Conversion of existing residential care home (C2 Residential Institutions) to 10 no. 1 & 2 bed flats (C3 Dwelling Houses)

3 Selsey Avenue Aldwick Bognor Regis

Thank you for your internet representation made on 21st March 2012 which has been recorded as **an objection** with the comments as follows:

6. Site;

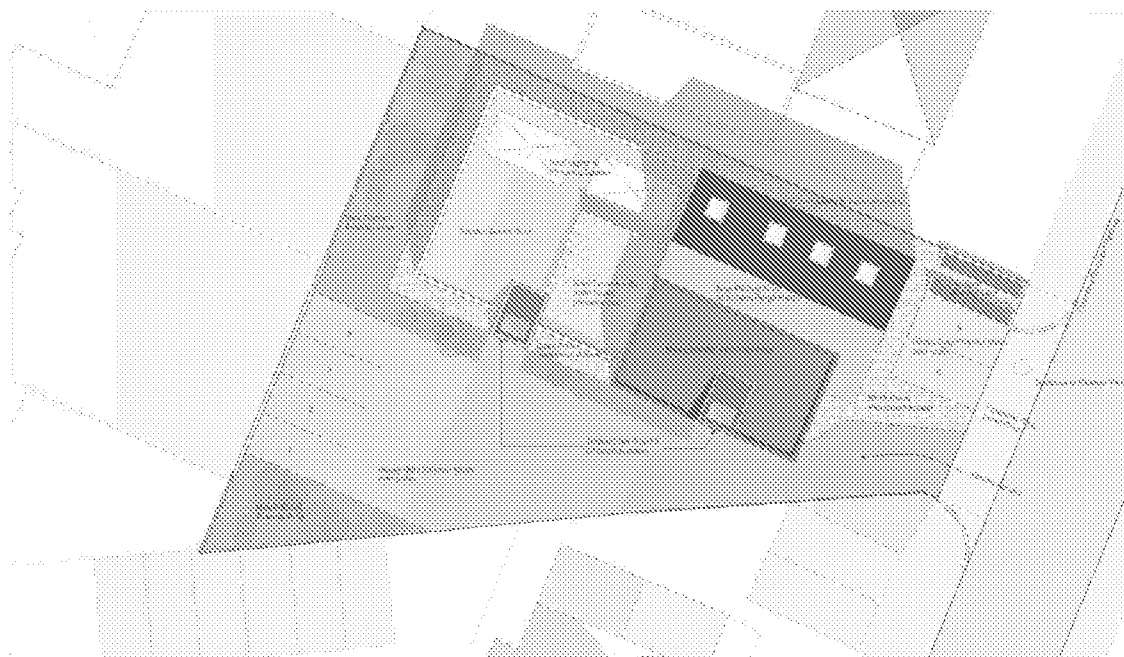
The location and amount of bins - 14 bins are located too close to our property at the front, will be unsightly and will smell, particularly in the summer. Who will be responsible for putting them back in storage on bin day? This needs to be addressed otherwise they will be left blocking the path and potentially blocking our drive. There is no detail regarding how the bin storage will look. □
